From: Amanda Scholes on behalf of Planning.Responses
Sent: 14 November 2019 08:47
To: Planning Scanning
Subject: FW: Land East of Tye Lane, Walberton - Revised Golf Details - WA/95/19/DOC

From: Bruce Taunton <[REDACTED]>
Sent: 13 November 2019 15:17
To: Michael Eastham <[REDACTED]>
Cc: Roger Spencer <[REDACTED]>
Subject: RE: Land East of Tye Lane, Walberton - Revised Golf Details - WA/95/19/DOC

DRAWING
Existing and Proposed
Golf Tee Box Postions

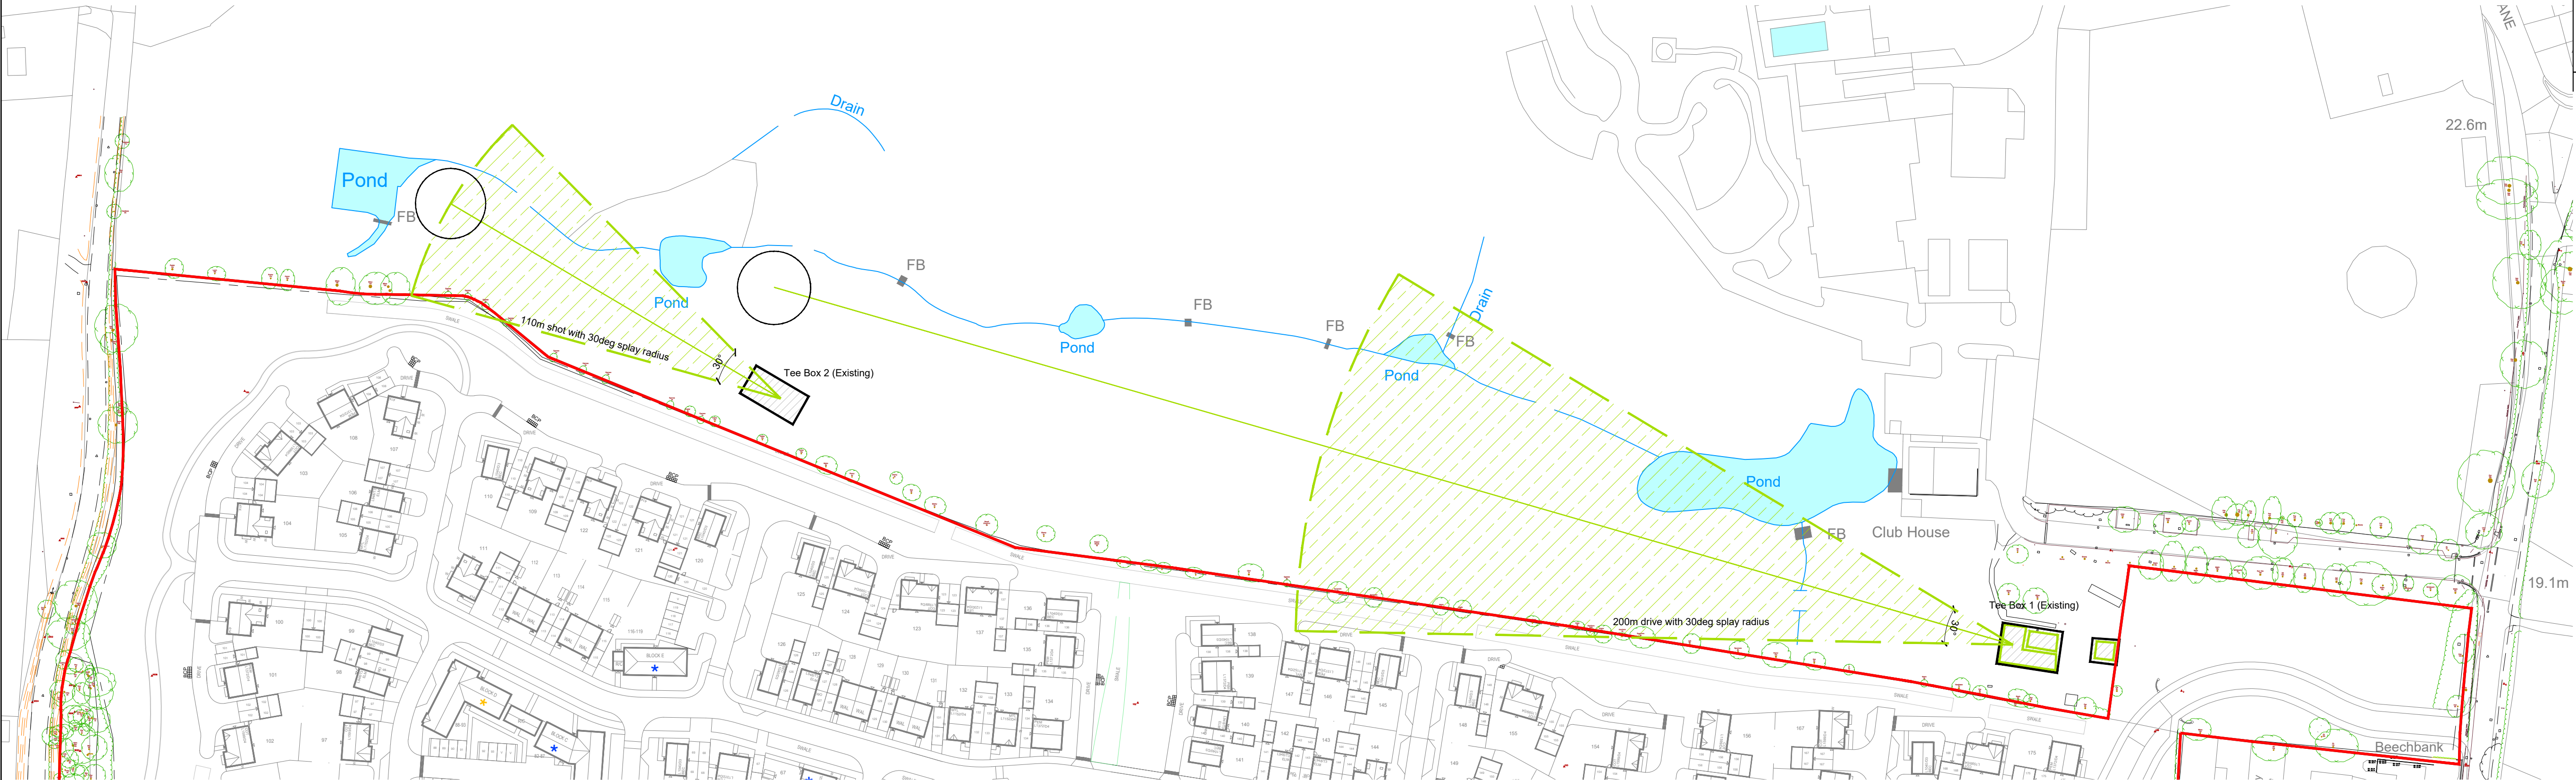
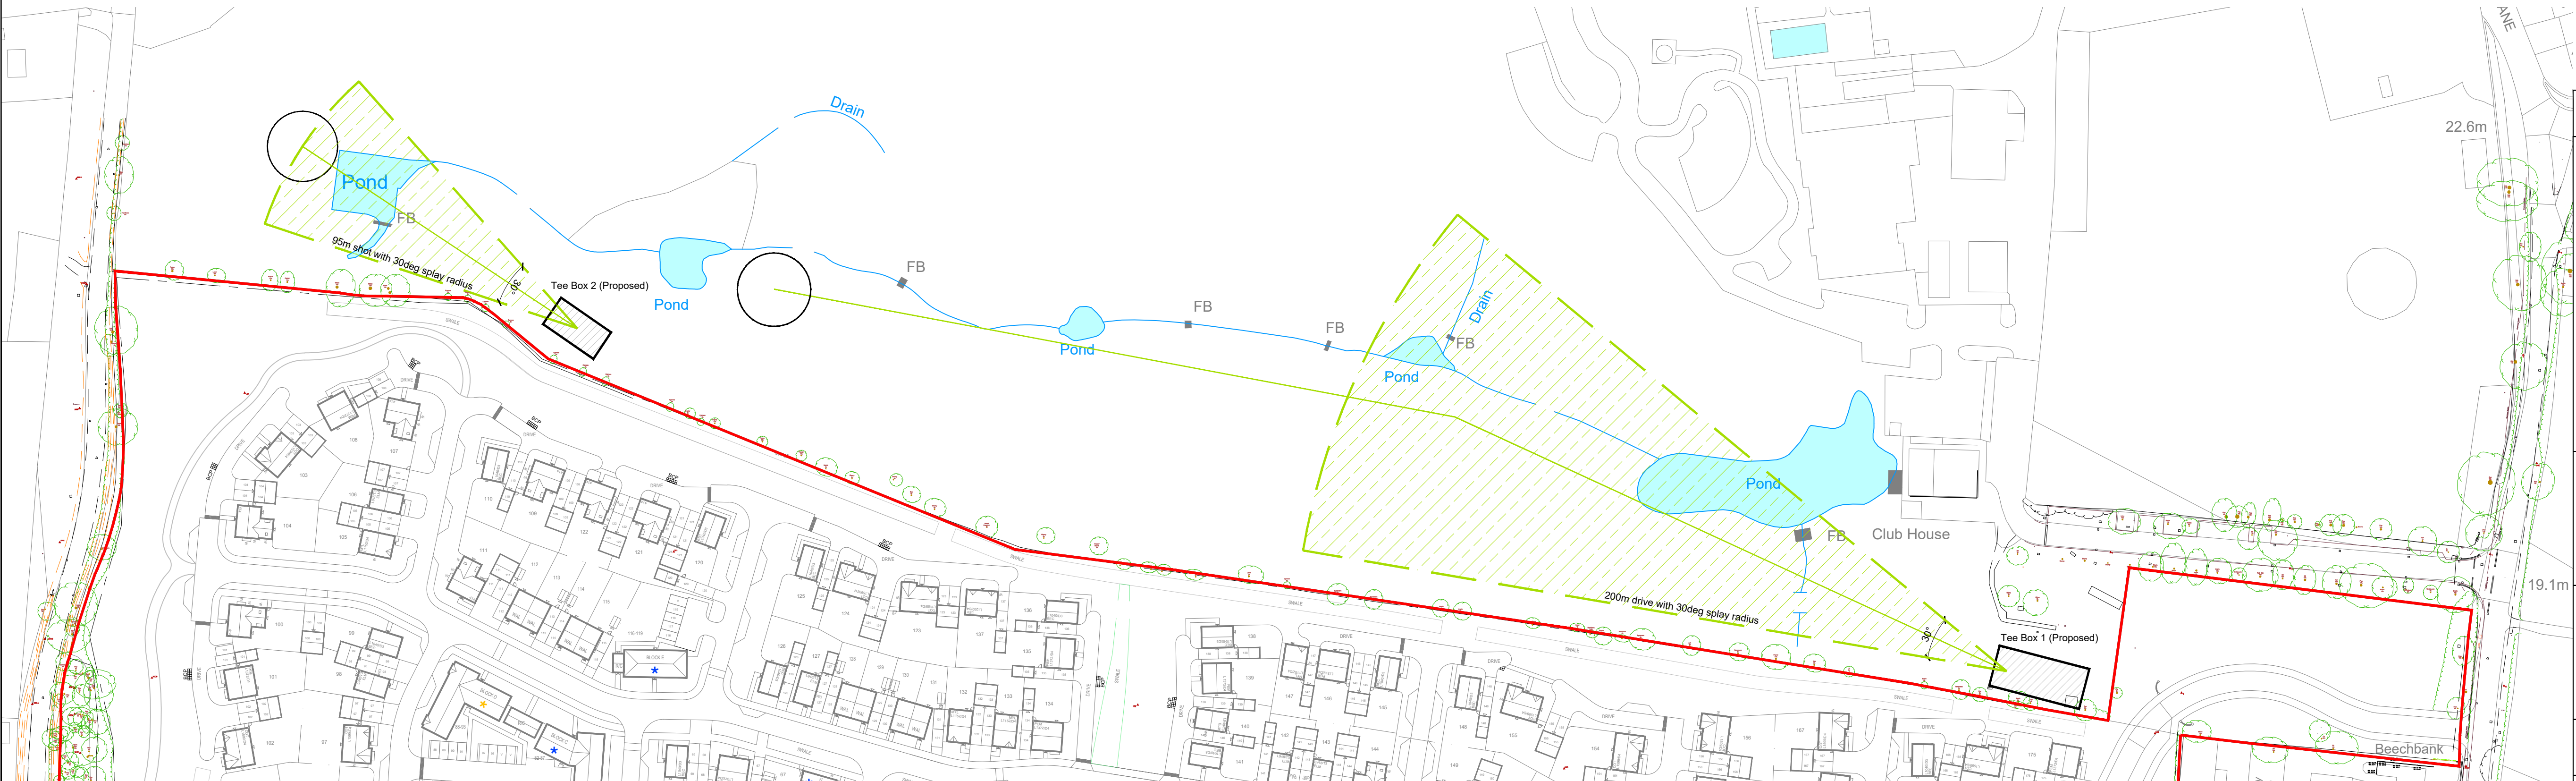
Further to our conversation and review of proposals I confirm that the golf net fence should be extended down alongside the length of the first tee box to protect the new development from wayward left handers teeing off at the rear of the tee box. In addition the following information is also required:-

Project	Land East of Tye Lane, Walberton		
Title	Golf Course Netting Indicative Detail		
Client	Linden Homes		
Scale	1:100 @ A3	Drawn	AL
Date	Sept 2019	Checked	GC
Drawing No.	CSA/3823/119	Rev	B

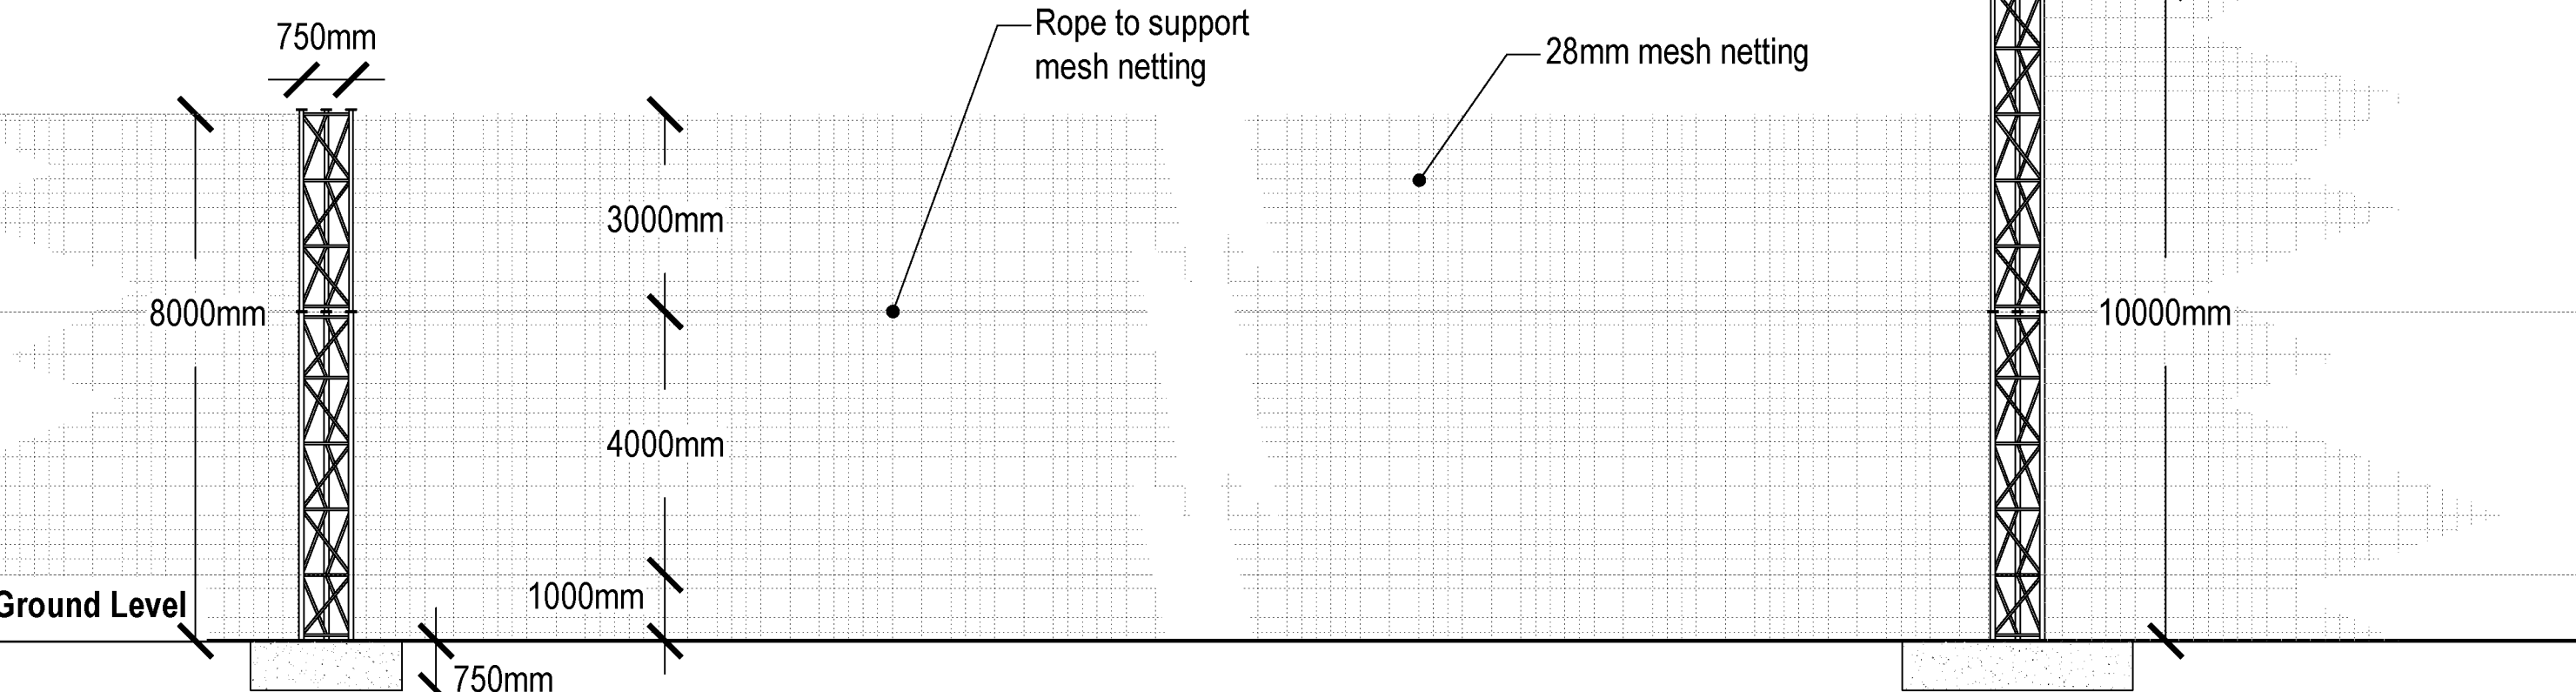
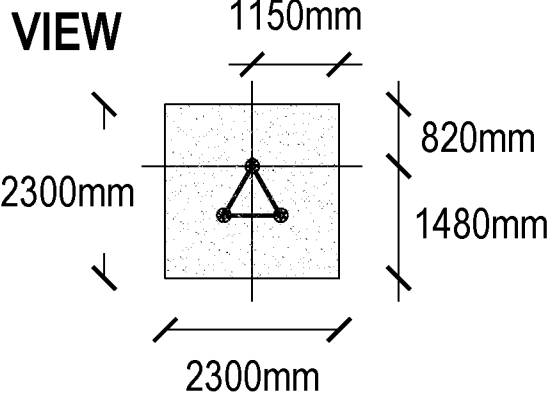
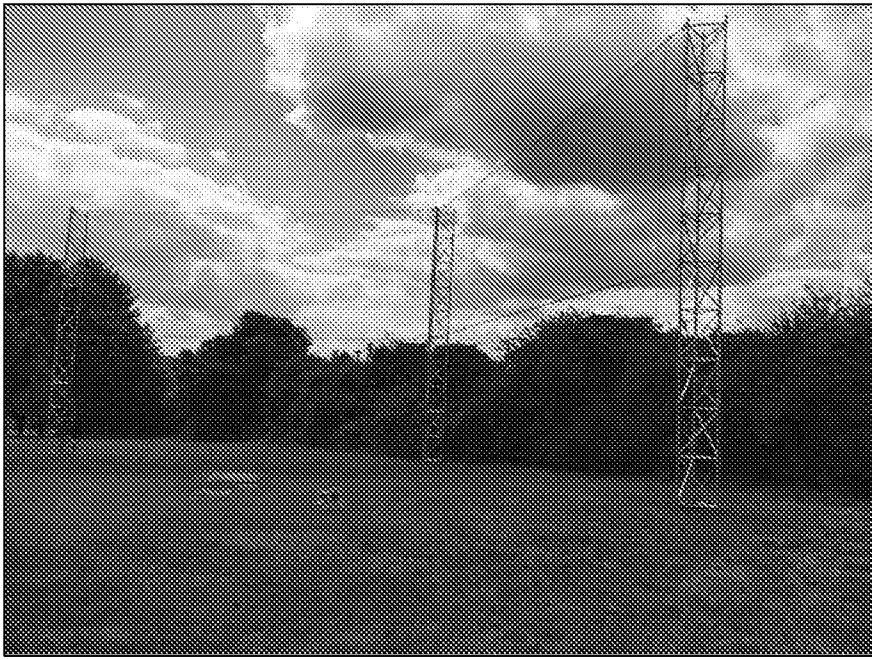
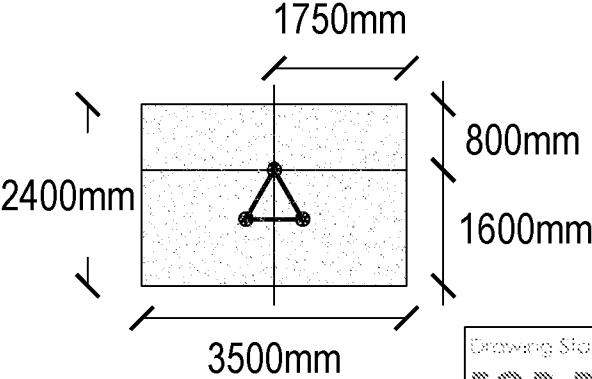
1. Fence post design calculations including its connections to the base suitable to resist the site wind loadings.
2. Design and details of fence post foundation suitable to resist sliding and overturning.
3. A drawing showing the location of all new fence post foundations in relation to trees and their protection zones must be provided. The drawing should also include the location/outline of the proposed swales.
4. Post foundations should not encroach the swale to prevent a bund forming or potential under-reaming and softening of the post foundation.
5. Sufficient room must be provided between the swale and fence for maintenance purposes and should be clearly indicated on the landscaping drawing. Cross sections through the fence and swale/golf post foundations will be needed to clarify the construction proposal.
